COUNTY COUNCIL'S RESPONSE TO CONSULTATION ON THE FOLLOWING DEVELOPMENT PROPOSAL

Application No: 19/00895/REM

Proposal: Reserved matters to 15/01326/OUT - Layout, scale, appearance and landscaping for the residential development of up to 280 dwellings and 34 space car park.

Response date: *31st July 2020*

PROJECT	Bodicote		
DRAWING	House Type Planning Drawing House Type:MAI, MOR,BLOX & LUT_VT Floorplans - Sheet 1 of 2		
SCALE	DATE	AUTHOR	REV
1:100@A1	Feb 2020	PH	A
JOB NO.	DRAWING NO.		
7942	BOD.HT.106		
CHARACTER AREA:	Main Street

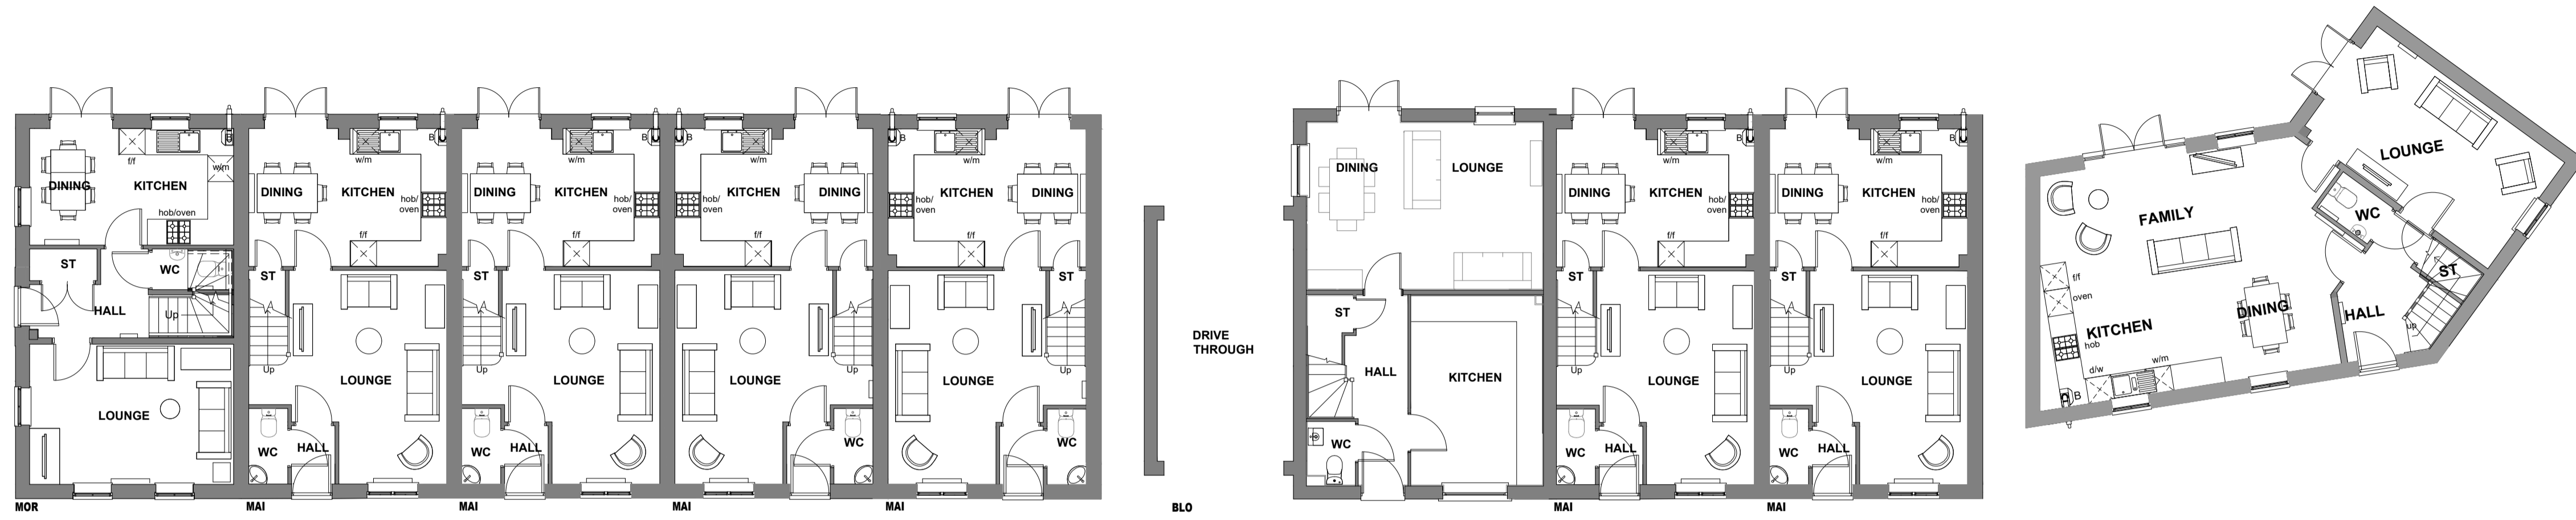
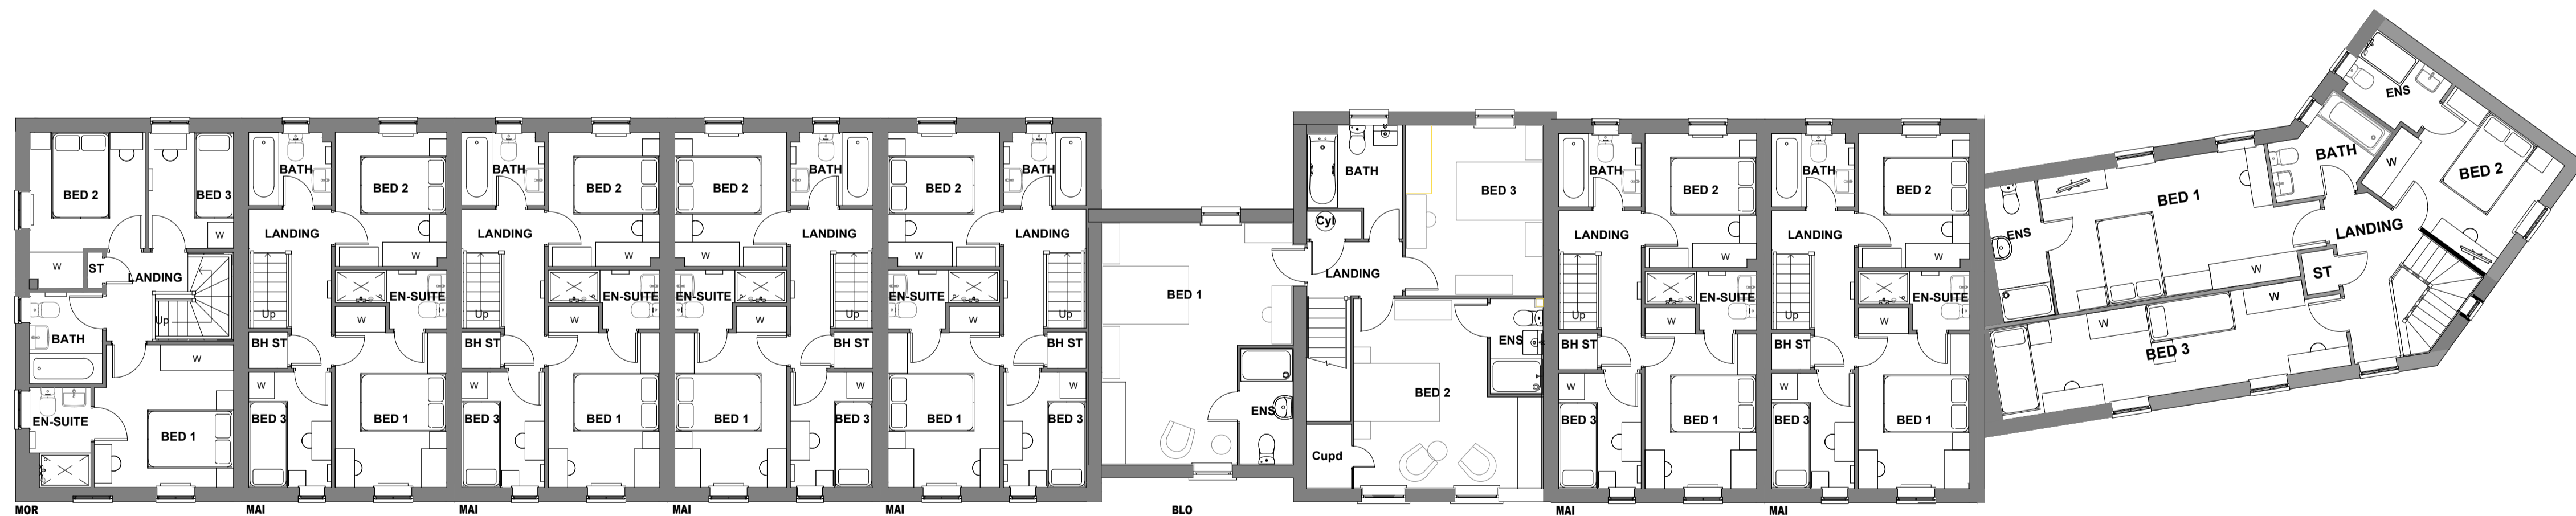
The snippet below is taken from a housing plan for plots 219-229 with the entrance measuring up to only 2.7m wide. This needs to be widened.
